memorandum

date December 12, 2019

subject CAO19-014 – Environmental Review for Headrick Property Redevelopment, Resubmittal

Critical Area Study Map
Headrick Garage and Pool Addition
8822 SE 62nd St
 Proposed Development Sheet 2/3
 Greg & Jennifer Headrick Project Number: 18303
 8822 SE 62nd St Drawn by: NP
 Mercer Island, WA 98040 Rev. 1: 10/25/2019

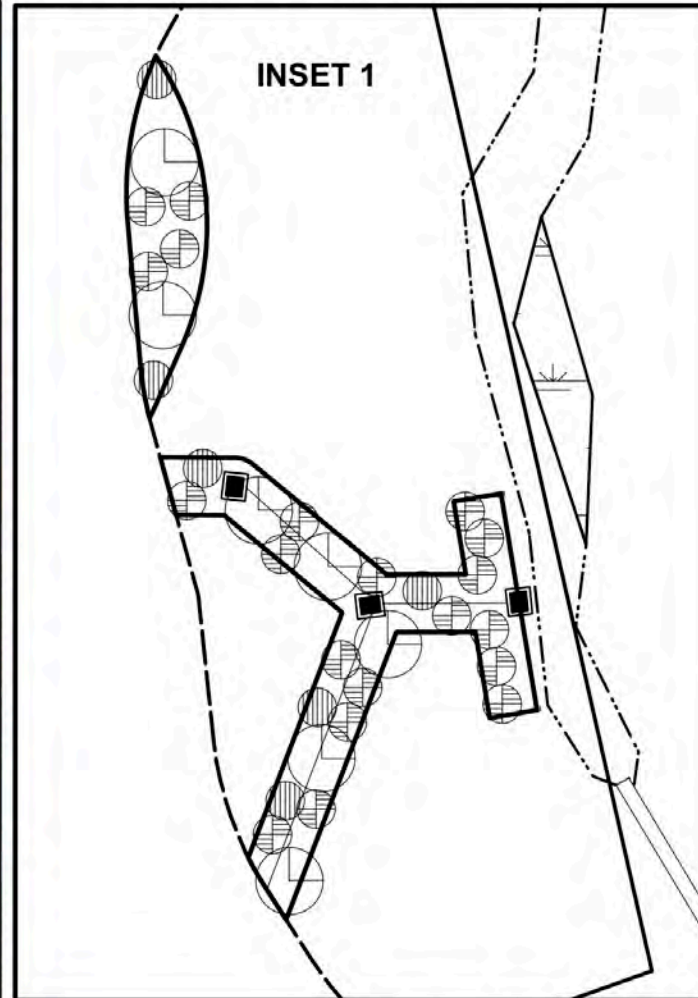
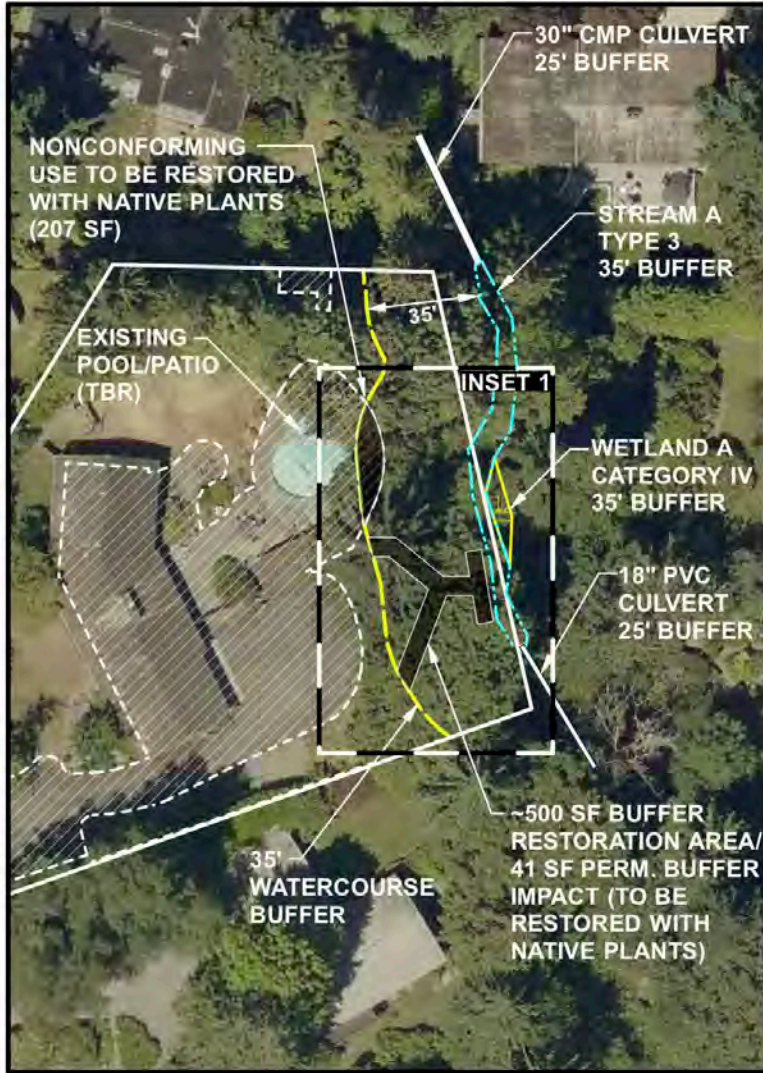
<i>Recommendation 3</i>	
Revise Performance Standard 1b1 of the Buffer Restoration Plan to require 70 percent aerial cover at Year 5, including suggestions for planting species and spacing to achieve that standard.	<p>Discussion in the Comment Response memo, and the revised CAS and Buffer Restoration Plan indicate that Performance Standard 1b1 has been updated to require 70 aerial percent cover at Year 5.</p> <p>It does not appear that the densities of proposed plantings within the buffer restoration area have been increased in the Buffer Restoration Plan based on our recommendations. There is no code requirement to increase plant density, but the mitigation project is required to achieve vegetation cover performance standards or contingency measures may be necessary. Should the planting plan fail to meet the 70 percent aerial cover requirement at Year 5, then additional plant density would be required at that time.</p>

<i>Recommendation 4</i>	
Consider revising the Project Plans to avoid direct impacts to Stream A from stormwater infrastructure construction.	Discussion in the Comment Response Memo and the revised CAS indicate that direct impacts to Stream A have been avoided.
